**Re: Philip Lovato & Sons Mechanic, 4101 Fourth St. NW,
Traffic Circulation Layout
Engineer's Stamp dated 2-19-14 (G14-D085)**

Based upon the information provided in your submittal received 2-24-14, the above referenced plan cannot be approved for Building Permit until the following comments are addressed:

Designed JSM	Drawn STAFF	Checked JSM	Sheet	1	of	1
File	LOV0114L	Date	FEBRUARY 2014

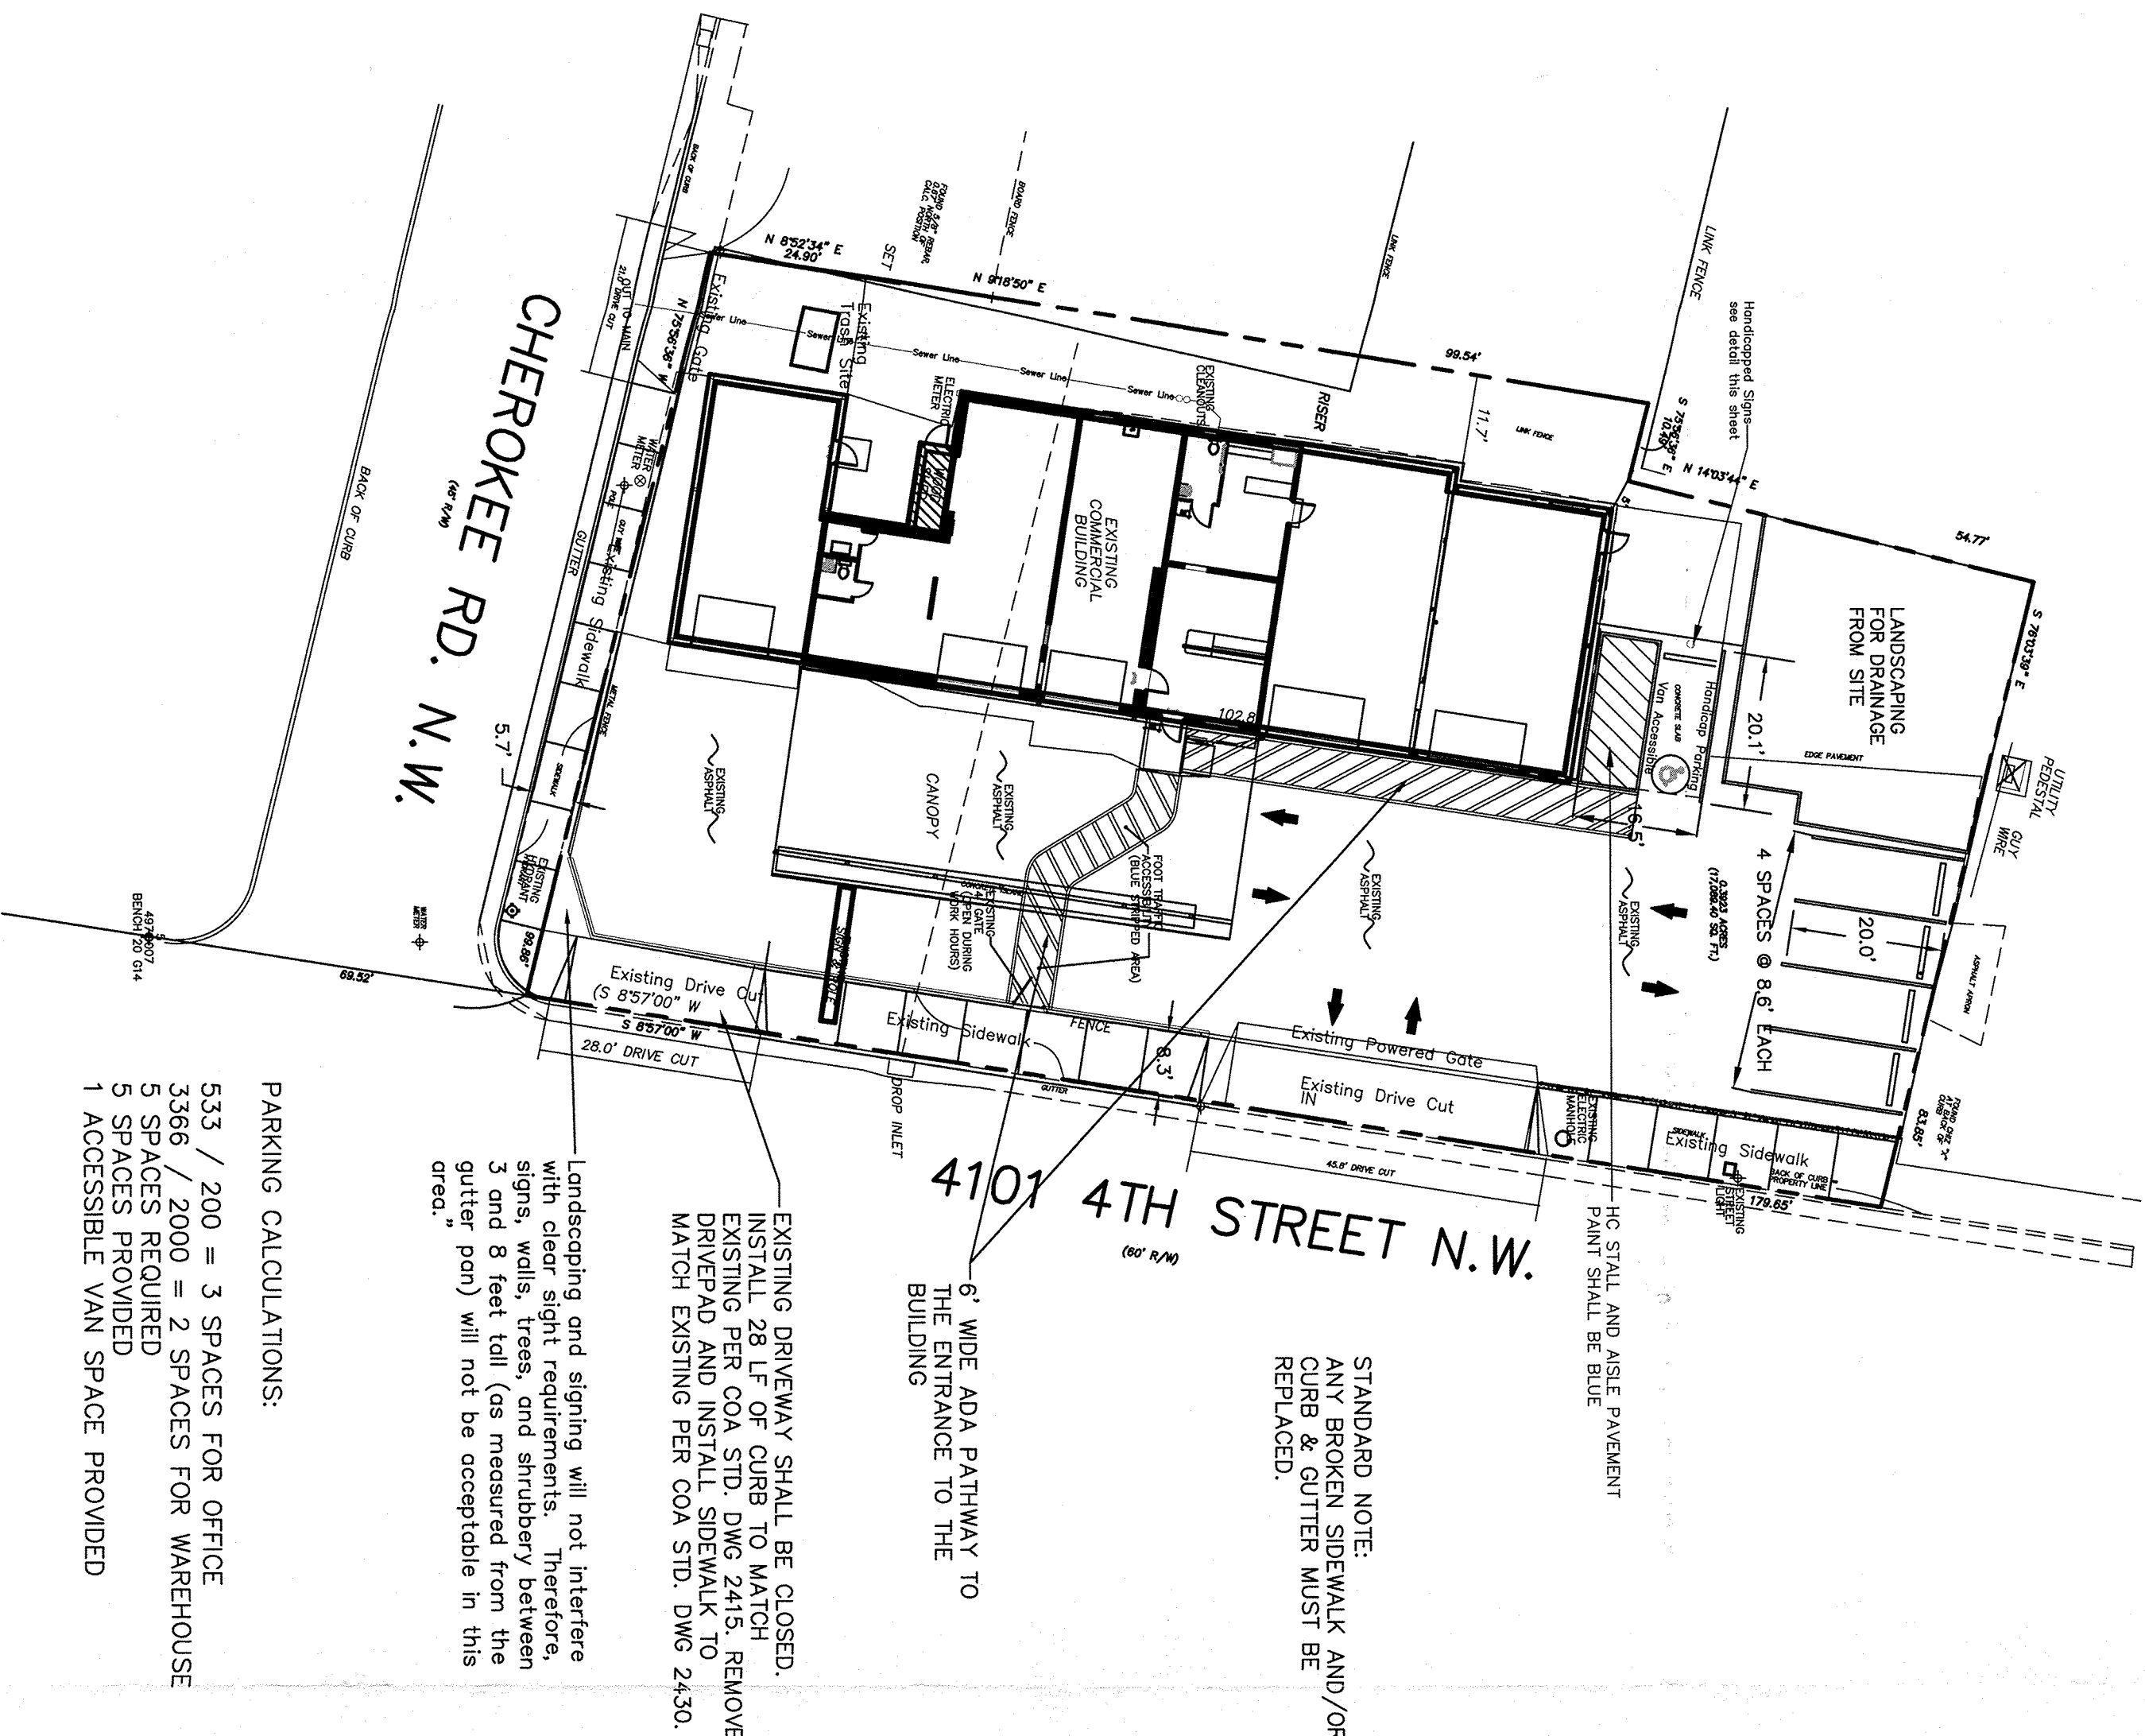
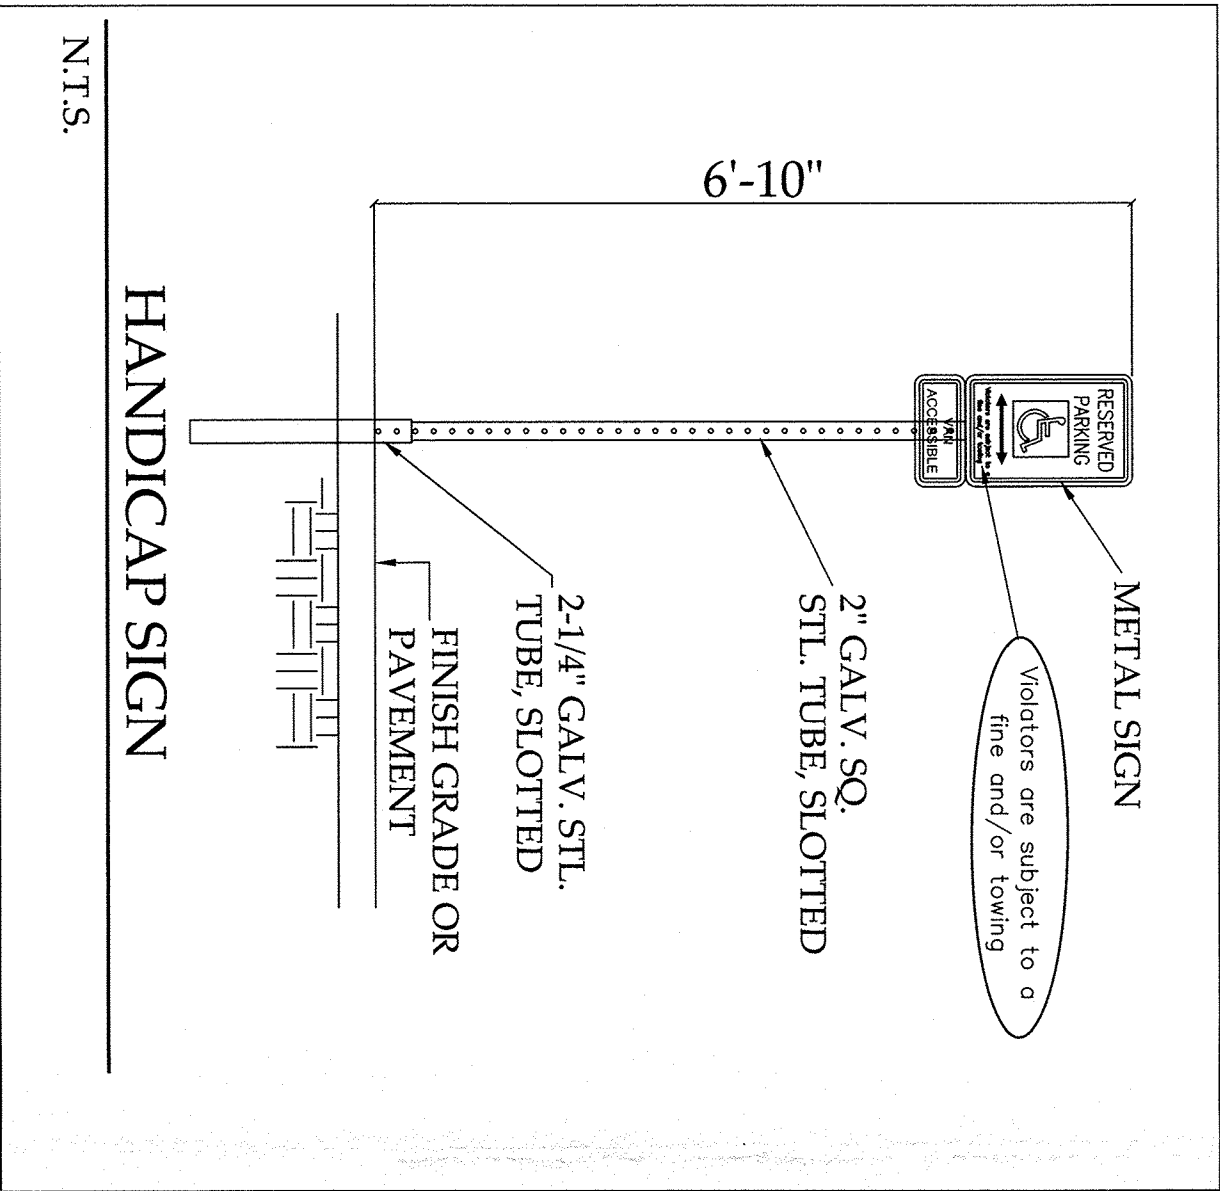
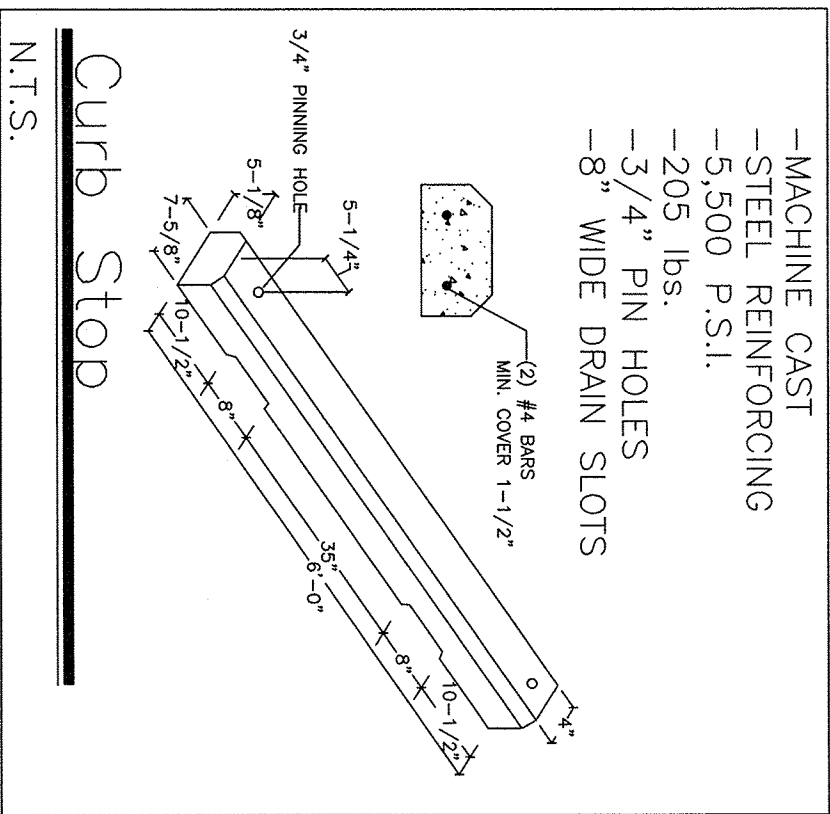
1. The development of this site must be in compliance with current DPM and ADA standards and regulations.
2. This site falls within the purview of the North Fourth Street Rank III Corridor Plan.

3. City Of Albuquerque Right-of Way dedication may be required.
4. Are the 7 lots going to be consolidated into one lot?
5. Zoning requests a meeting to review site for compliance.

6. Is landscaping required by zoning? If so, please provide landscaping plan with next submittal. Per the *Development Process Manual*, Chapter 23, Section 7, Part B.6, curbing should be used to separate landscaping from parking areas and pedestrian ways as well as providing a physical perimeter for harvesting water. This must be clearly shown on the TCL.

7. Please add the following note: "Landscaping and signing will not interfere with clear sight requirements. Therefore, signs, walls, trees, and shrubbery between 3 and 8 feet tall (as measured from the gutter pan) will not be acceptable in this area."

8. The existing fence may be within the COA ROW. If so, an encroachment agreement with the City may be required.
9. The existing sign and pole may be within the COA ROW. An encroachment agreement with the City may be required.

10. The existing fence may interfere with the sight distance of the intersection. Please provide a sight distance exhibit (see the *Development Process Manual, Chapter 23, Section 3, Part D.5 Intersection Sight Distance*).

11. Per the DPM, a 6 ft. wide ADA accessible pedestrian pathway is required from the public sidewalk to the building entrances. Please label ADA and dimension.

12. Per the DPM, a 6 ft. wide ADA accessible pedestrian pathway is required from the HC parking stall access aisles to the building entrances. Please clearly show this pathway and provide details.

13. A five-foot keyway is required for deadend parking aisles.
14. Please list the width and length for all parking spaces.
15. It is not apparent what type of pavement surface is being proposed. A hard driving surface will be required as part of this proposed project for parking area and drive aisles.

16. Will Solid Waste be picking up Refuse at the proposed location? If so, location must be approved by Solid Waste.
17. Please show the location of the nearest driveway on the adjacent lots.

18. Define width of the existing sidewalk on each frontage.
19. Is the frontage sidewalk ADA compliant?
- Dimension the distance between the existing power pole & guy wires and existing fence.

- Indicate where concrete and asphalt surfaces are located.
 - Is there ADA compliant pedestrian paths across drive pads?
 - Is the corner ramp ADA compliant?

20. Abandon curb cuts must be replaced with sidewalk and curb & gutter. A build note must be provided referring to the appropriate City Standard (#2430 and #2415).

21. Since Fourth St is an arterial roadway, driveways with right in / right out only have a minimum driveway width of 30 feet (see the *Development Process Manual*, Chapter 23, Section 6, Part B.8).
22. If the site has left turn access, the drivepad has a 36-foot minimum width.
23. Please include two copies of the traffic circulation layout at the next submittal.
